# **REPORT on the IMPLICATIONS for EUROPEAN SITES**

## **Proposed Keadby Next Generation Power Station Project**

Planning Inspectorate Reference: EN0110001

19 May 2026

Plate 8B.2: Stack Height Determination (Hydrogen Firing)

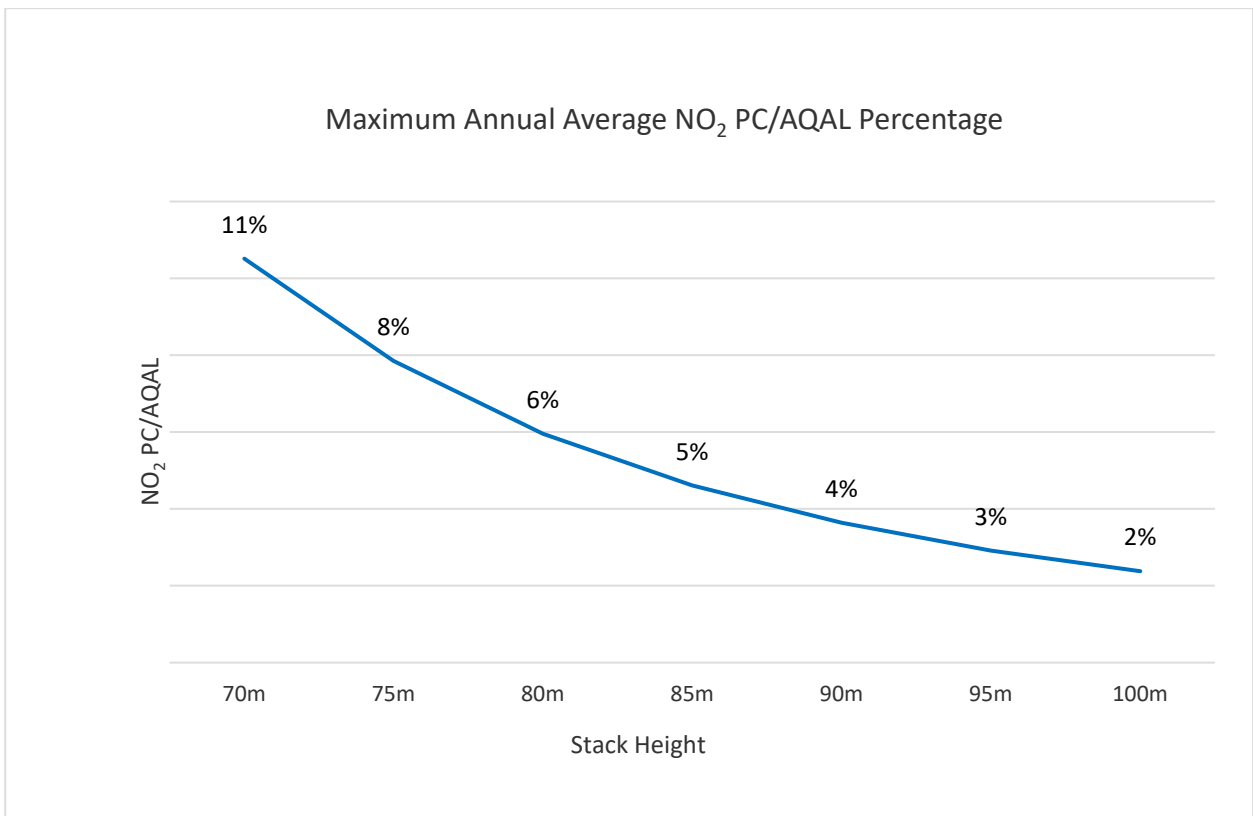
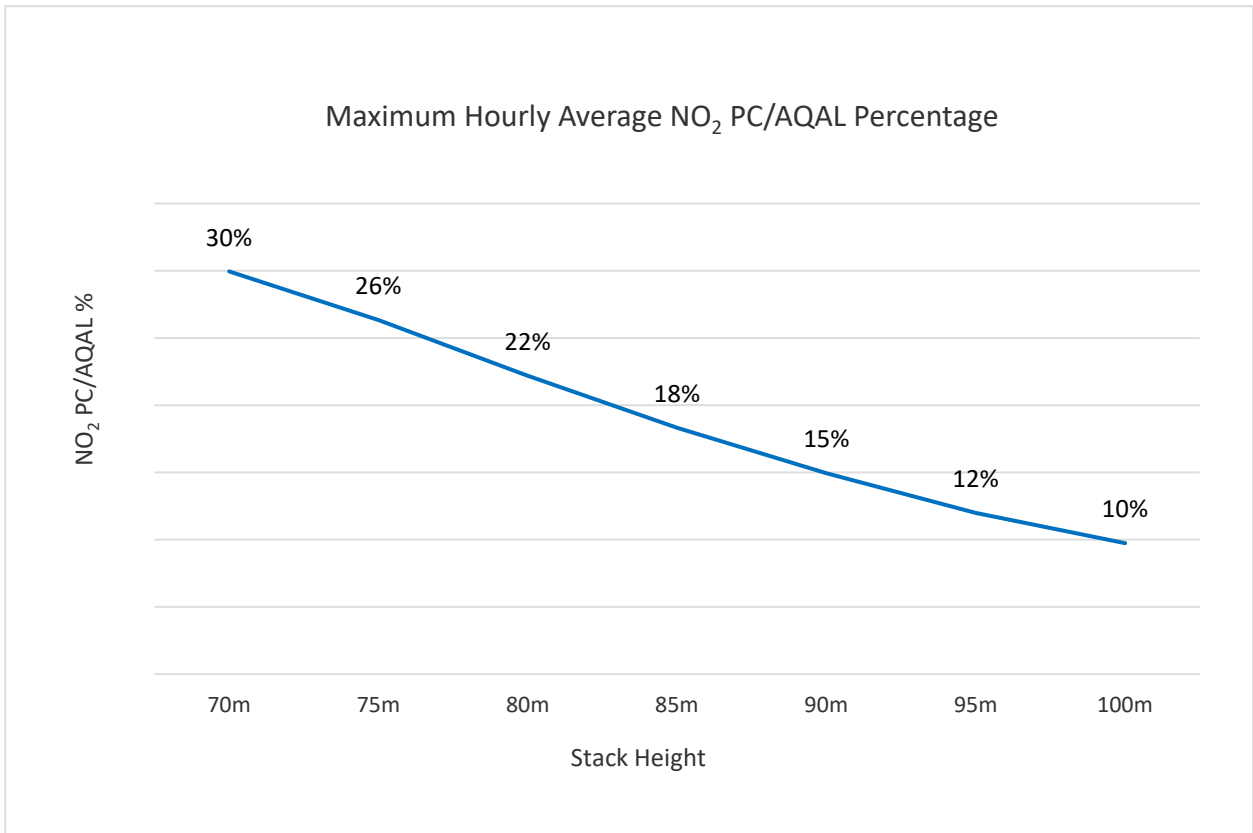
2.3.7	Atmospheric pollution (operation)	NE (NE18 [RR-013]) considered the worst-case parameters to be acceptable within the Rochdale envelope approach and acknowledged the sensitivity testing for stack height. Nevertheless, NE sought confirmation that "improved dispersion" provided by a taller stack would not lead to potentially significant impacts at protected sites further from the development.  The applicant does not agree that this scenario would occur. It confirmed that if a higher stack was required, the impact on protected sites would be checked [RR-013]. ES Appendix 8B (paragraph 8B.5.6 [REP3-017]) states that any change in the stack height that may result after further detailed design of the proposed development would be remodelled to ensure that the predicted impacts remain in accordance with the predicted impacts presented in this assessment at all receptors.  NE [REP3-033] considered this matter resolved at DL3 [REP3-033] stating "commitment in the DCO to further modelling should stack height be amended at detailed design stage to ensure no additional protected sites would be affected".	The ExA notes DCO Requirement 5(1)(c) on detailed design which states that the height of any stack must be at a level at which the environmental effects will be no worse than those identified in chapter 8 of the environmental statement.  <b>RIES Q1 (to NE): Is NE content with the wording of DCO Requirement 5(1)(c)? If not, why not, and what changes does it propose?</b>  <b>RIES Q2 (to the applicant): Provide further justification of how the maximum adverse effect has been assessed for the Thorne and Hatfield Moor European sites, with respect to stack</b>

<p><b>heights and operational emissions to air.</b></p> <p><b>RIES Q3 (to the applicant):</b>  <b>Regarding DCO Requirement 5(1)(c), how does the applicant define ‘worse’ and who is responsible for enforcing this?</b></p>
